Re: 4401 Alexander Blvd NE
Site Plan – DRB Re-Submittal
Project Number: PR-2018-001252
Application Number SI-2022-02328

On behalf of Curia New Mexico LLC (f/k/a Oso Biopharmaceuticals, LLC), Burns & McDonnell is pleased to resubmit this Site Plan – DRB as per public meeting comments stated on January 11th, 2023. Comments are either addressed within respective drawings or below.

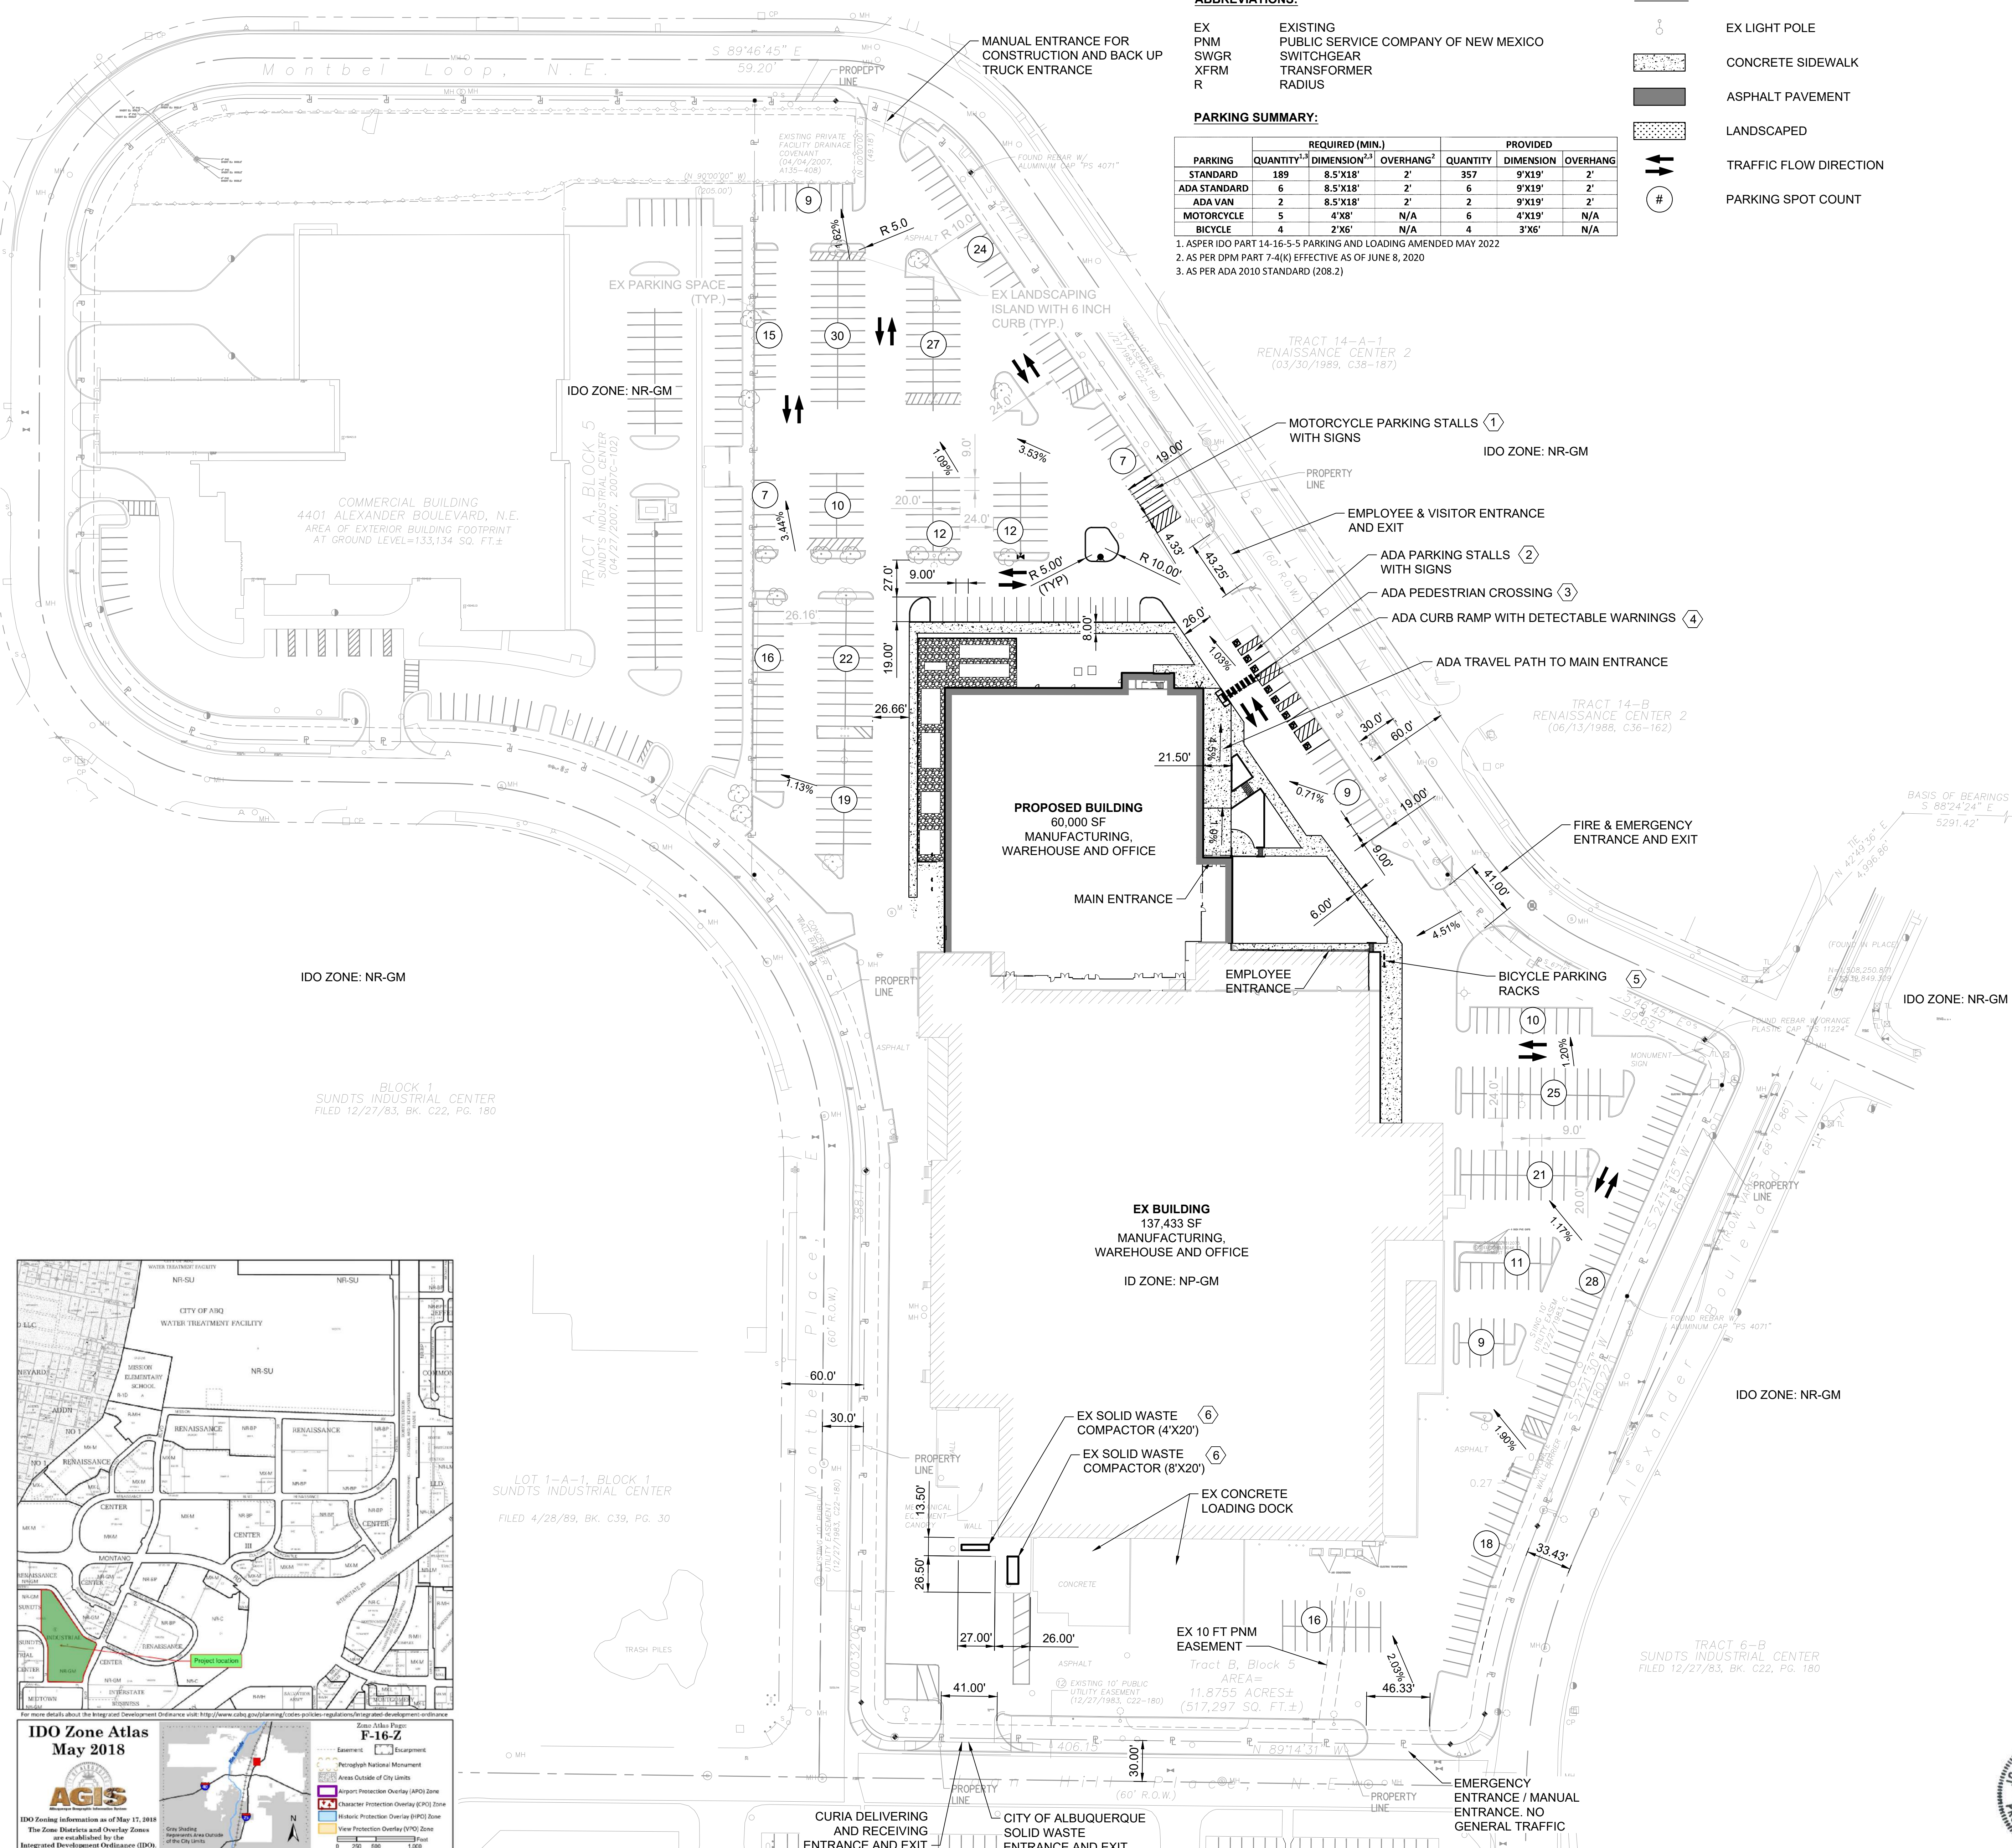
6. Need to show the various square footage types of use in all buildings, both old and new. Must show detailed, combined parking calculations based on each of those specific use requirements, as per IDO section 5-5(c), Table 5-5-1, including total required and provided.
 - a. Response: Refer to drawing number CS100.
